Project# 1009090

15DRB-70393 MINOR - PRELIMINARY/ FINAL PLAT APPROVAL

DEVELOPMENT REVIEW BOARD MEETING – June 26, 2013

Item #1 Project #1009090

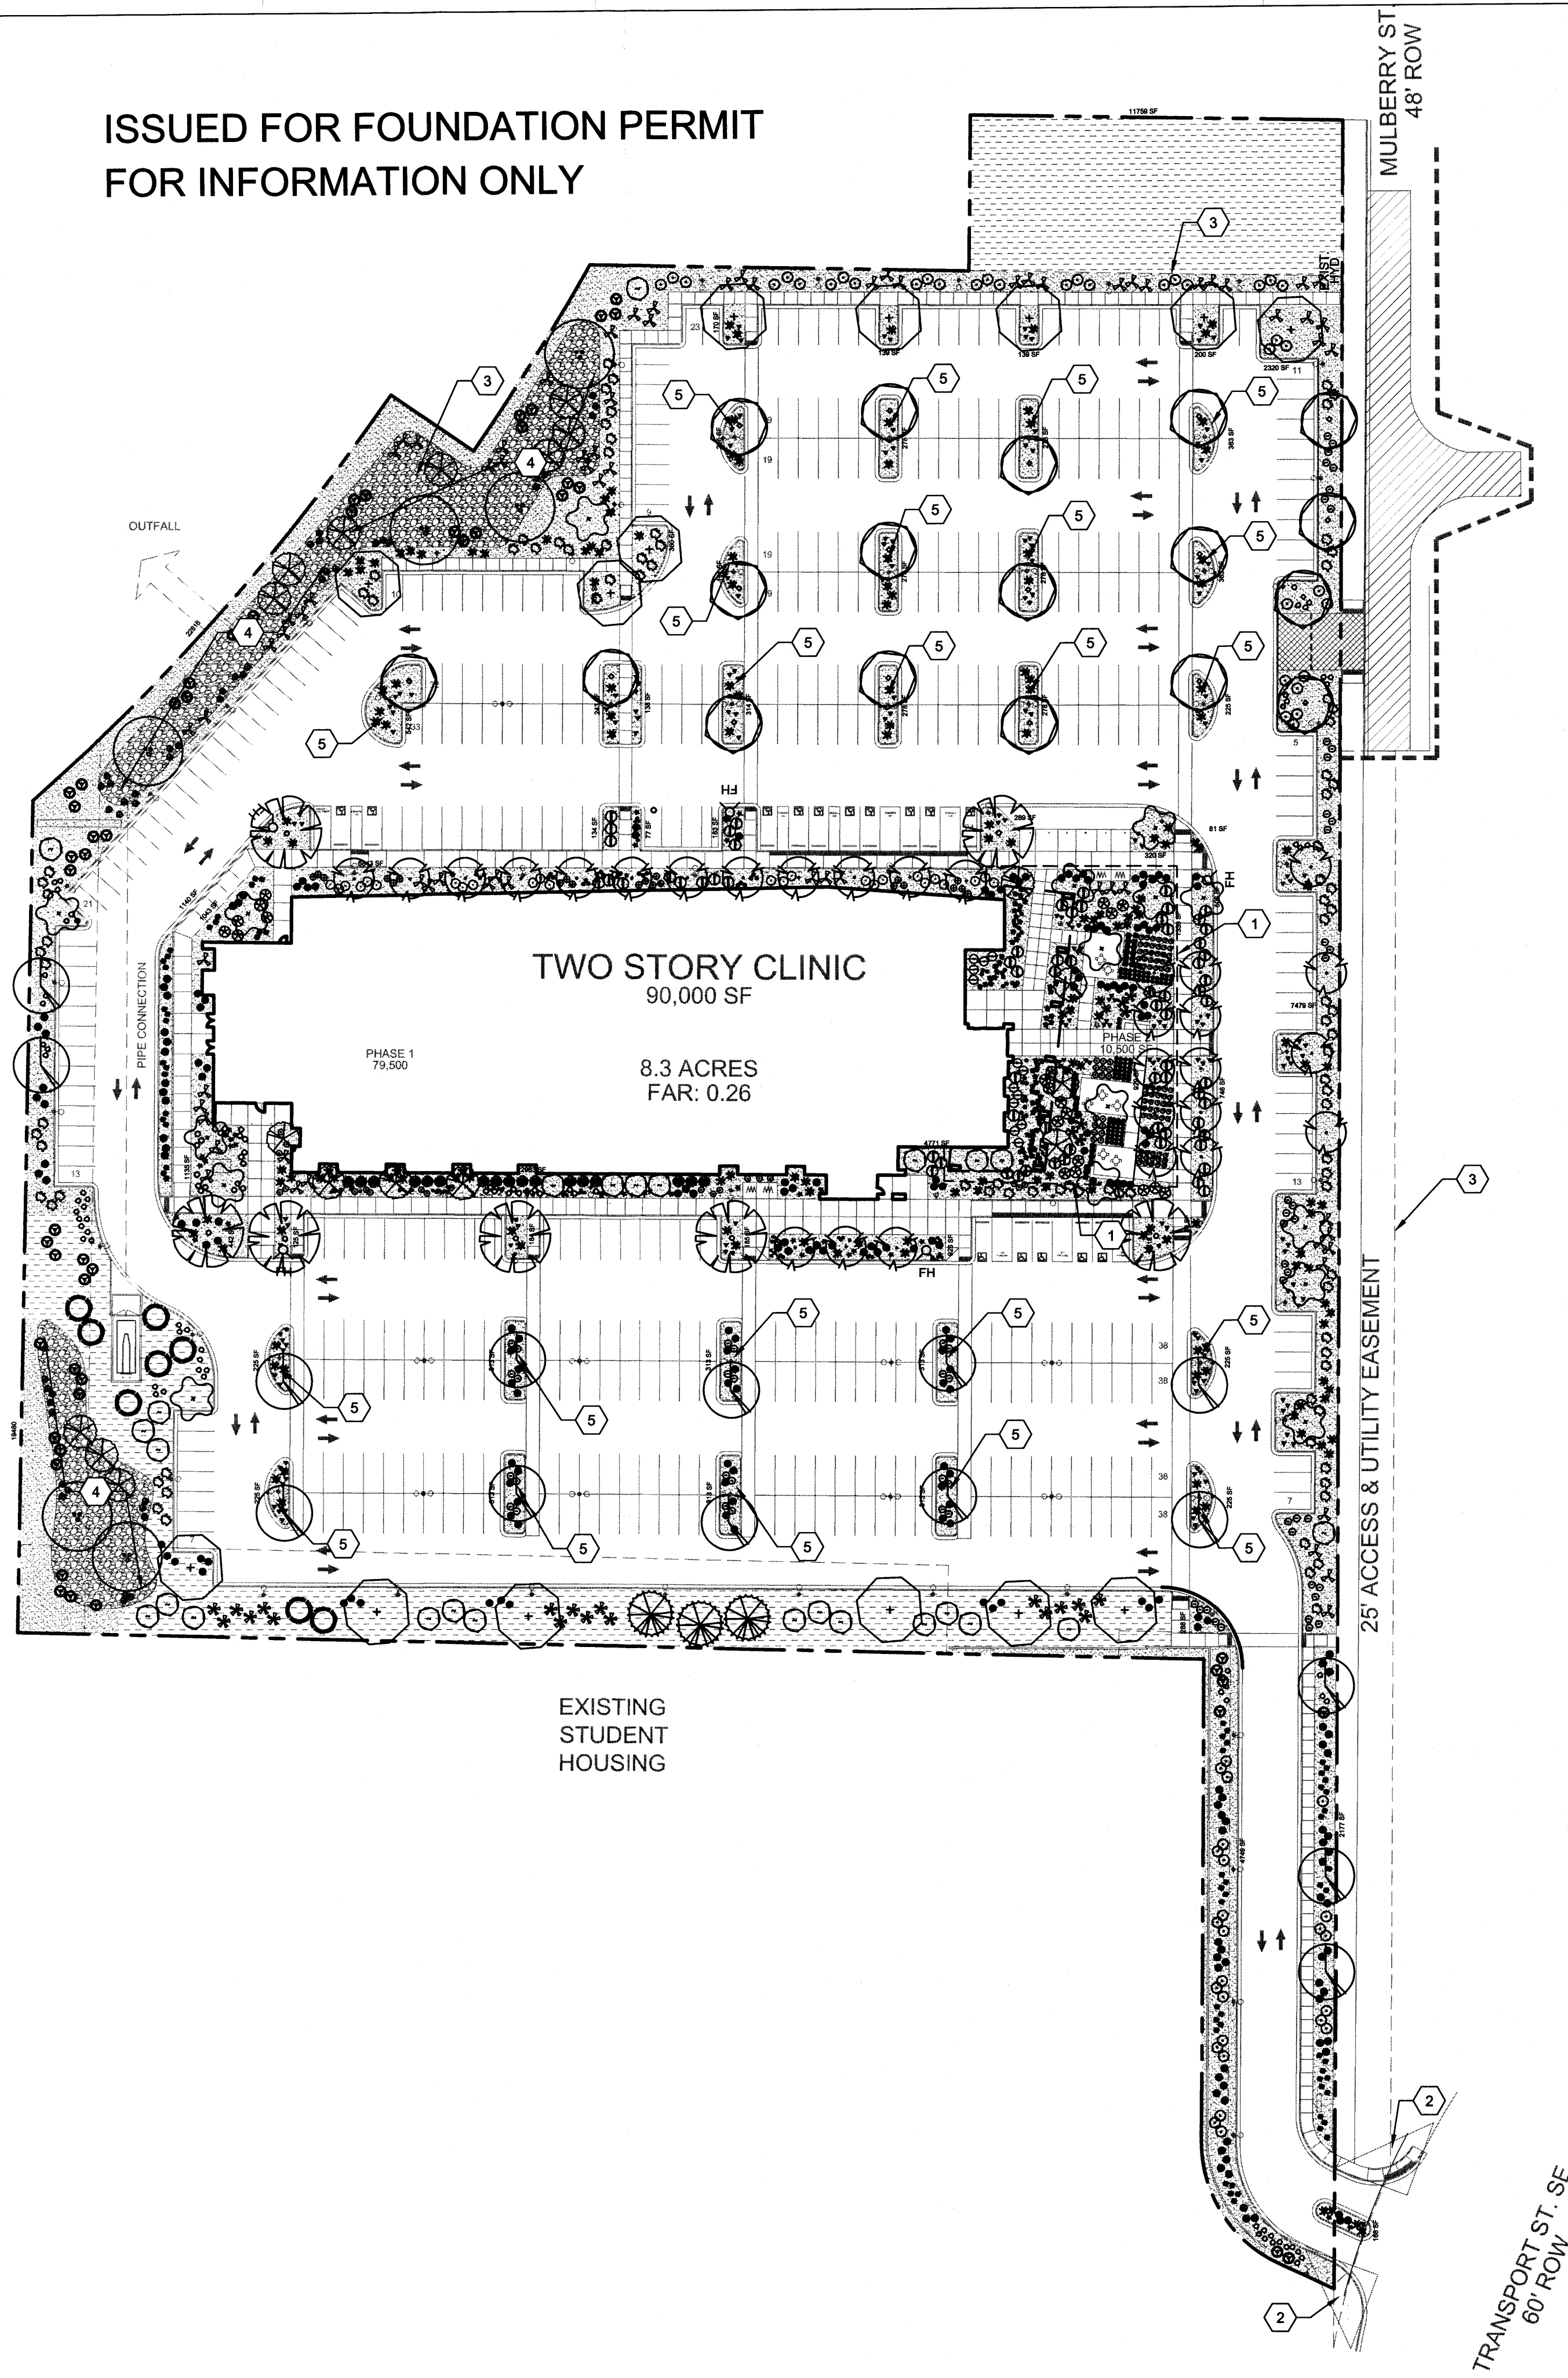
Landscape Plan does not show property line or street right of way so cannot tell if a Streetscape Agreement will be necessary for construction of landscaping in City Right of Way. If landscaping is within City *Row, Agreement will be required. cad*
